**Consultation Response from KC, Conservation and Design**
**2020/94055 Land opposite, 4, Coalpit Lane, Upper Denby, Huddersfield, HD8 8UF**
**Erection of 7 dwellings and associated access works**
**Date Responded: 25.2.21      Responding Officer: Sue Oakley      Responding Ref:**

DRAWING TITLE
HOUSE TYPE DRAWING

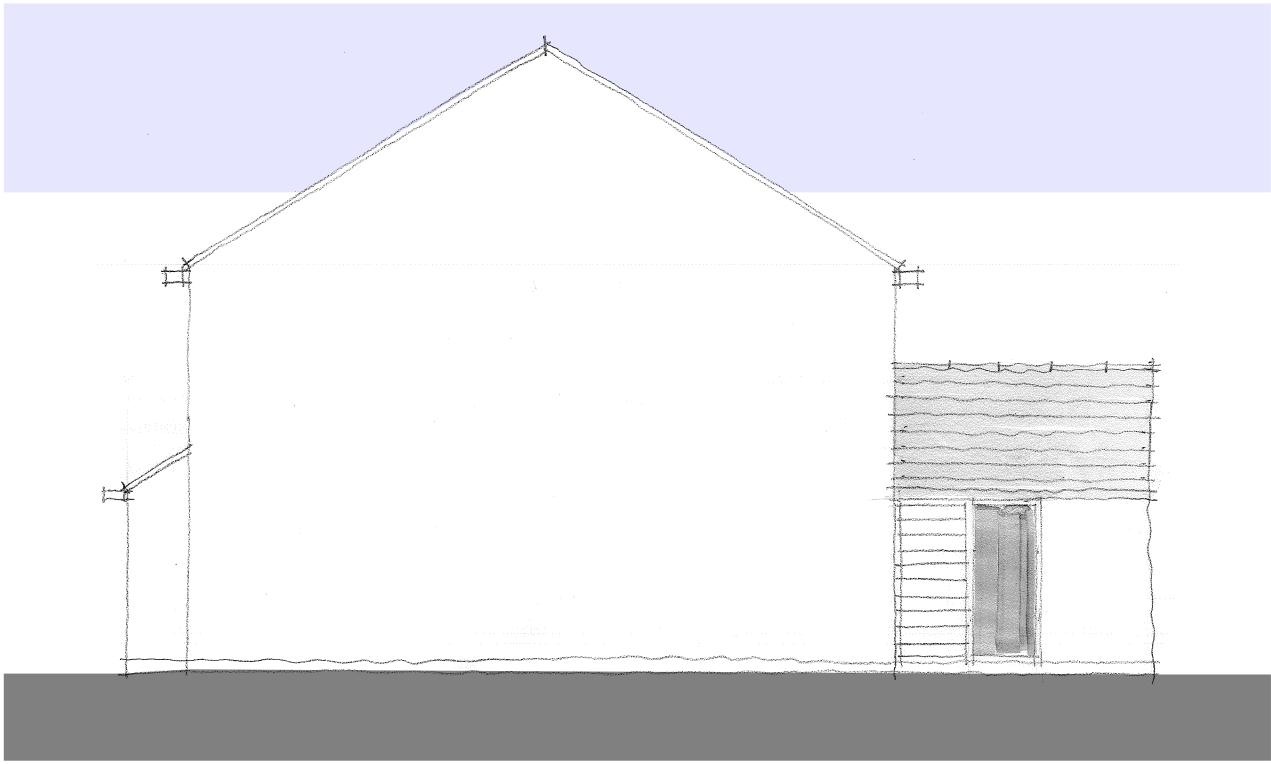
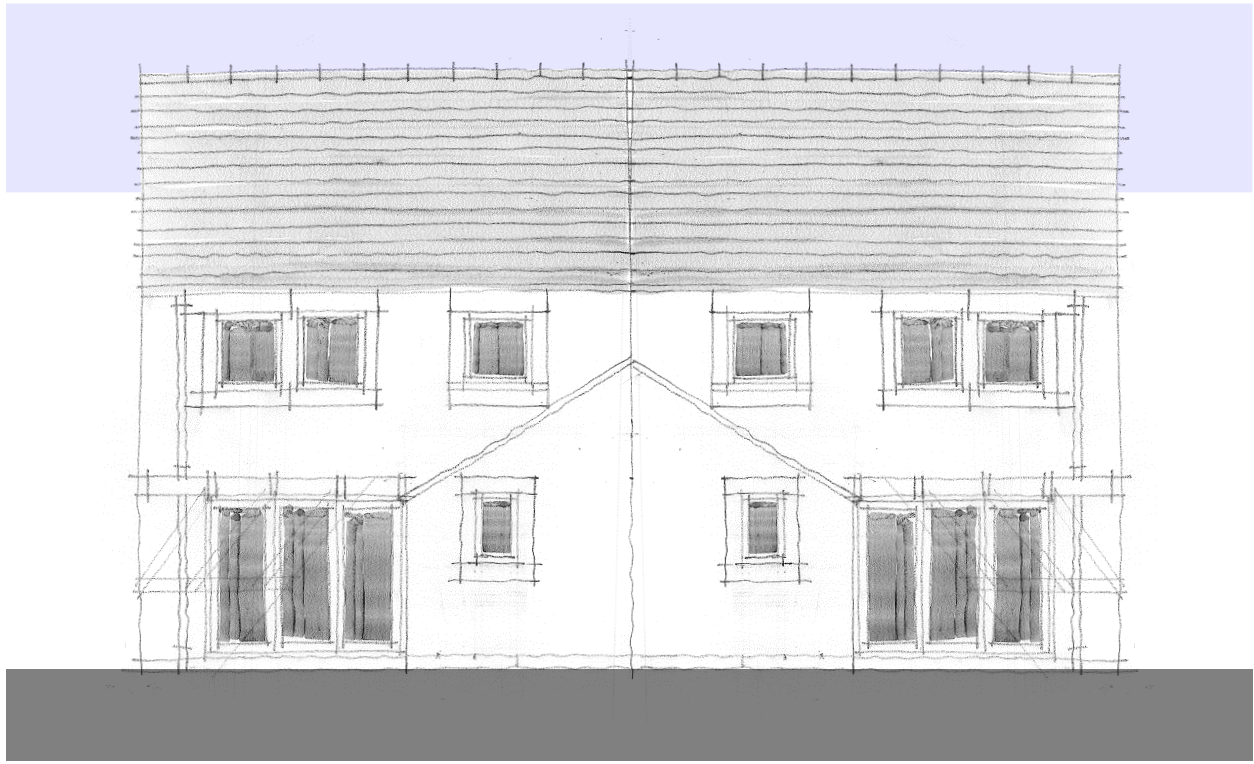
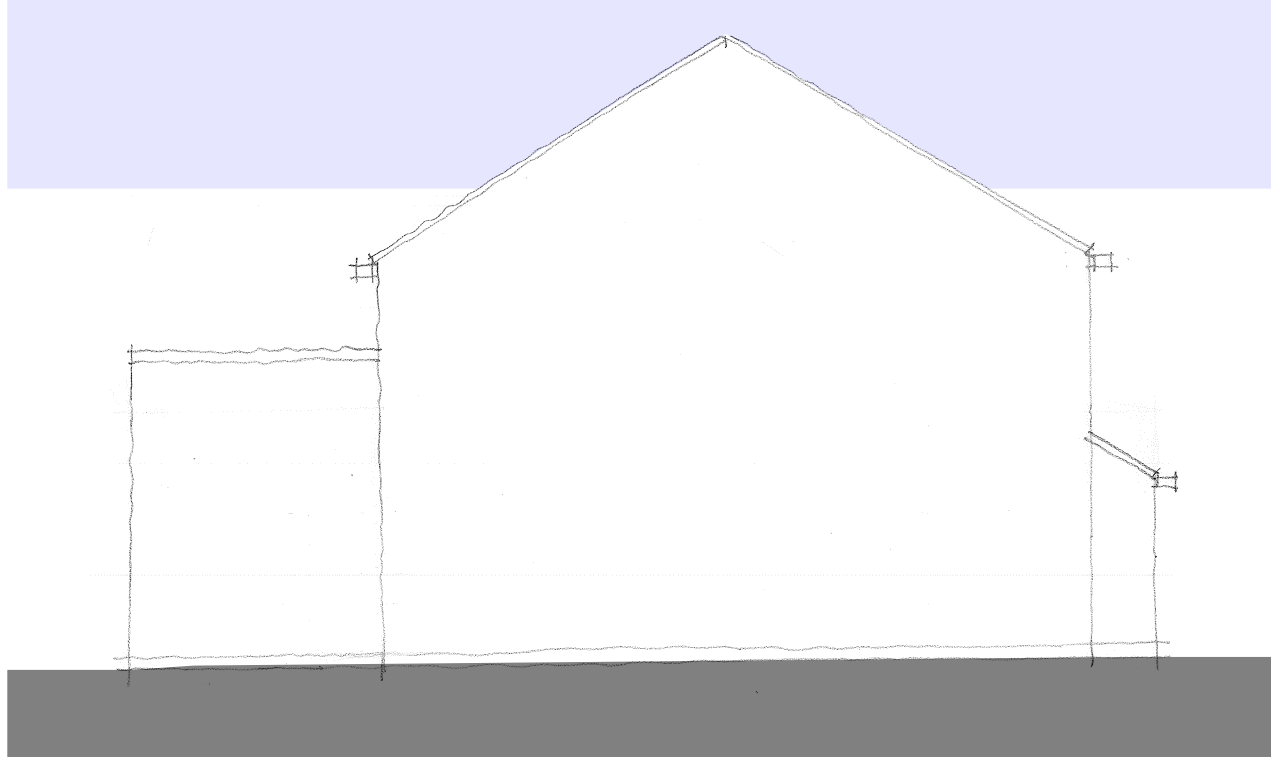
In addition, limited consideration has been given to Kirklees Local Plan policies LP24 and LP35. Although the overall scale and design of the properties broadly reflect the local vernacular, I would suggest that some revisions are made to the detailing, with more detail shown in the proposal drawings. Examples would be pitched roofs for the porches and rear annexes rather than flat roofs, stone gutter corbels, artificial stone slates and chimneys. Clarification should be sought to ensure that the window surrounds are constructed in natural and not artificial stone. I would request that some design changes are made, particularly to the properties at the southern end of the site.
